13 December 2019

SUBMISSION TO IVANHOE ESTATE REDEVELOPMENT - SSD-8707

This submission has been prepared by Urbis on behalf of Morling College (Association of Baptist Churches of NSW and ACT) who own and operate a 2.7-hectare landholding at 122 Herring Road, Macquarie Park. The purpose of this submission is to provide comments in relation to the proposed travel routes following the removal of the existing roundabout at the intersection of Ivanhoe Place and Herring Road.

Travel Route Options

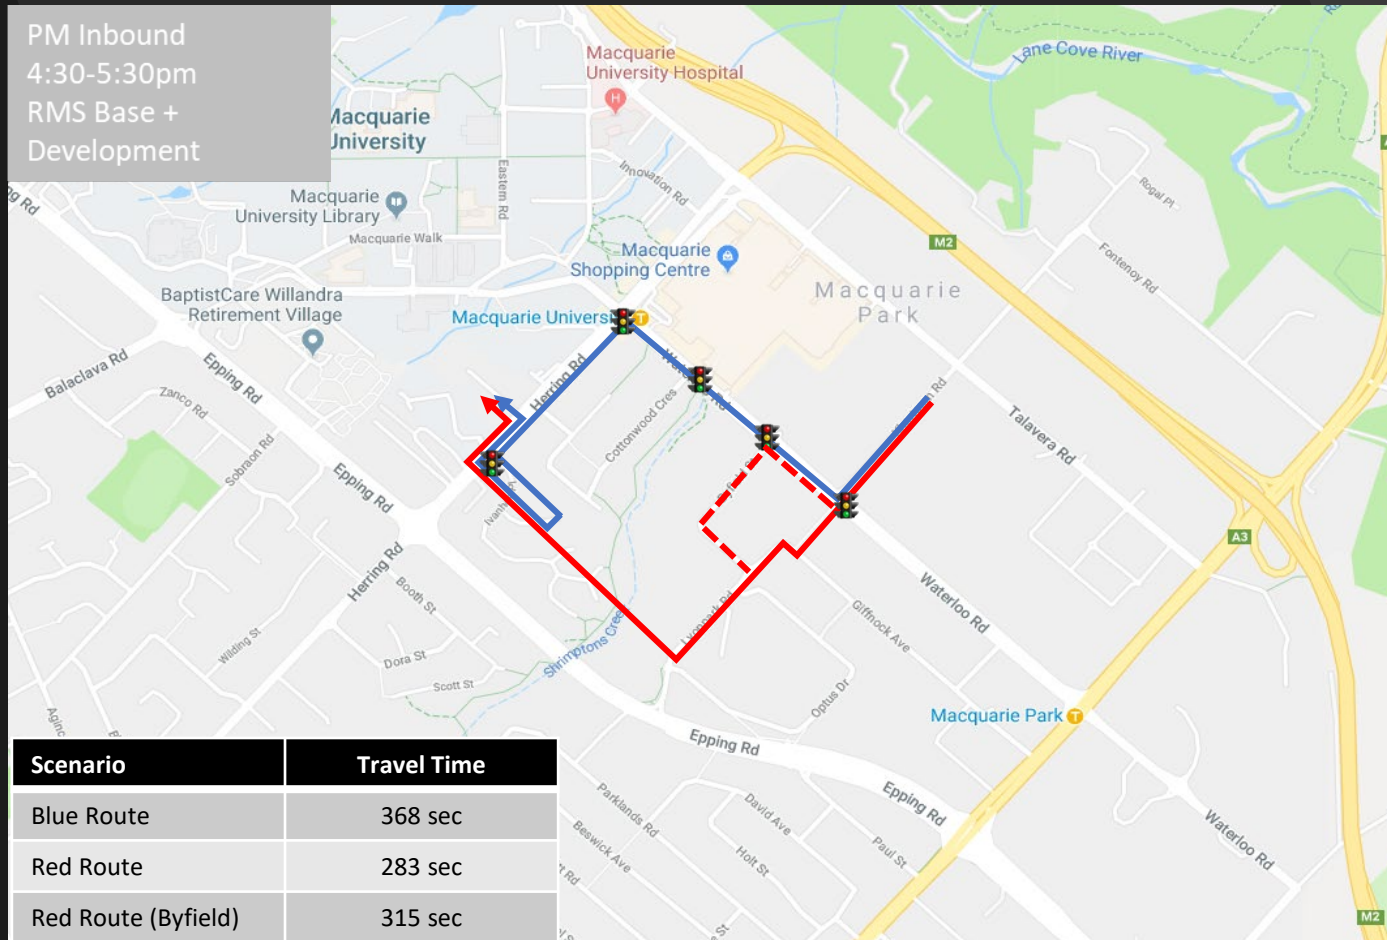
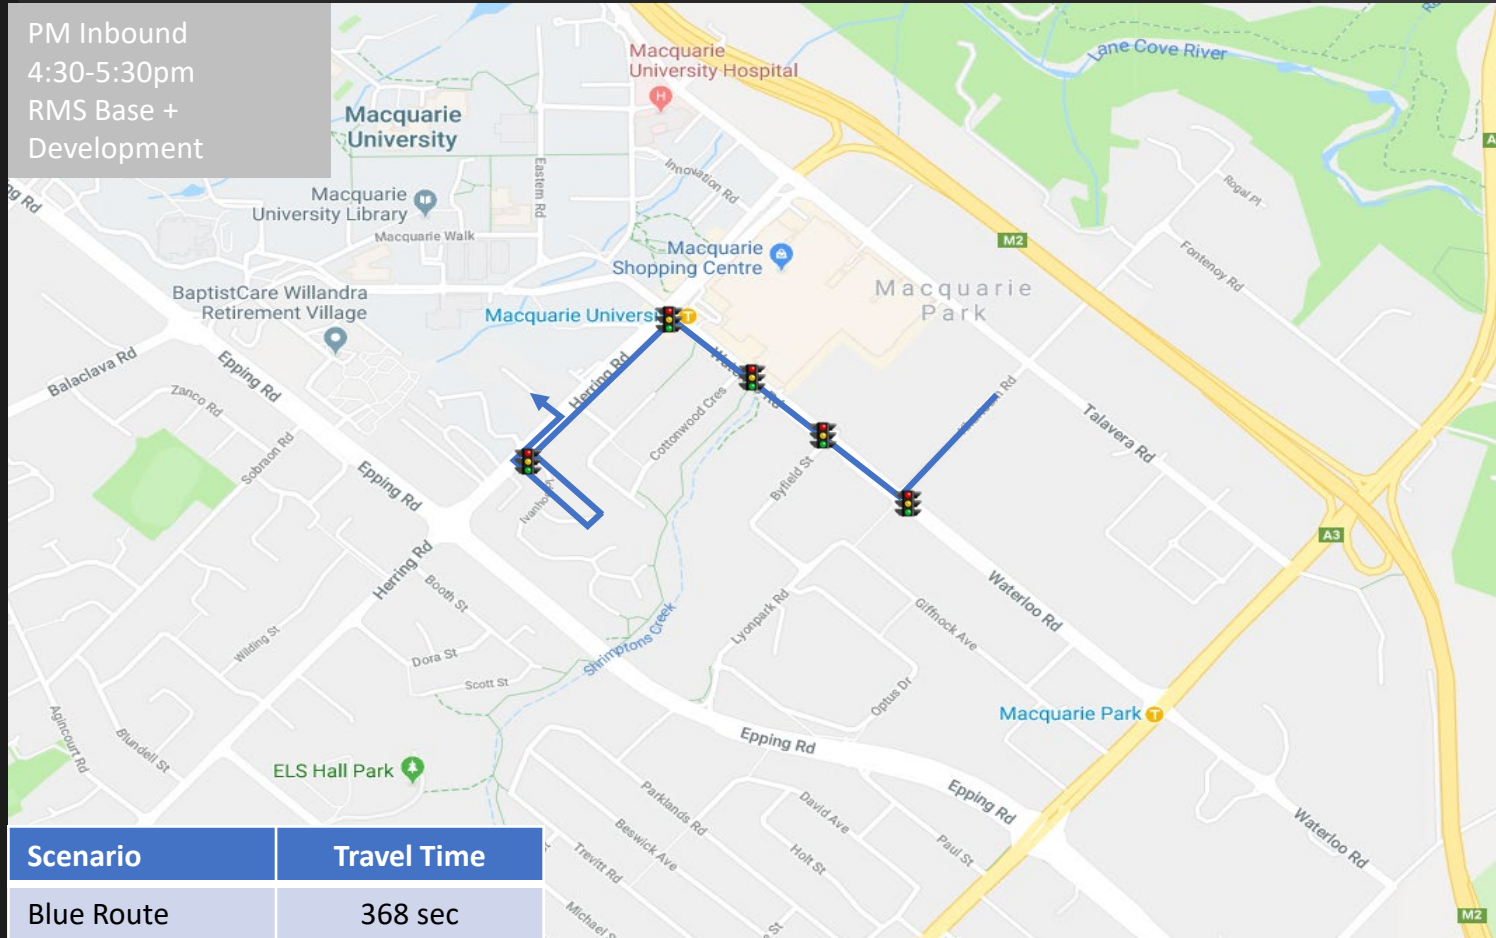
The current proposal submits that based on surveys undertaken in 2016 and 2017, a peak 'u turn' movement at the intersection was estimated as being 41 veh/hr. In response, the scheme proposes that the impacted trips can utilise the following alternative travel routes once the upgrade comes into effect:

Option 1. Travel through the internal road network of the Ivanhoe Estate Development; or

Option 2. Use an alternative route of Byfield St – Lyonpark Road – Main Street (via the proposed new bridge connection).

- We are generally supportive of option 2 provided this option is implemented as soon as the signalised intersection upgrade works are completed or no later than further building work DA's are committed at Ivanhoe (in addition to Building A1 and C1 currently under assessment).
- The proposed travel route offered by option 1 is not supported for the following reasons:
 - The length and complexity of the route presents potential safety conflicts between those using the internal road for more passive reasons (navigating car parking, picking up/ dropping of children, visiting the shopping precinct etc) and those who are using it as a thoroughfare.

- It is not convenient and requires the driver to navigate several turns over a significant distance.
- The likelihood of illegal manoeuvres under this option is considered to be high.
- The assumption that the proposed routes provide consistent travel times with the current situation is questioned when the existing roundabout is far more direct than what is being proposed by option 1.
- The assumption that 41 veh/hr use the existing roundabout as a u-turn facility is based on old survey data and does not account for the redevelopment plans by Morling College under LDA2019/0264.
- The proposal is inconsistent with RMS' commitment to providing a u turn facility in Ivanhoe Place.

If the existing Ivanhoe Place/ Herring Road roundabout is removed, then it is recommended that an alternative option is developed in lieu of option 1 that provides safe and convenient travel for vehicles approaching from Herring Road. The construction of a roundabout in Ivanhoe Place would address the issues raised in this submission, as well as those raised previously by RMS and Ryde Council.
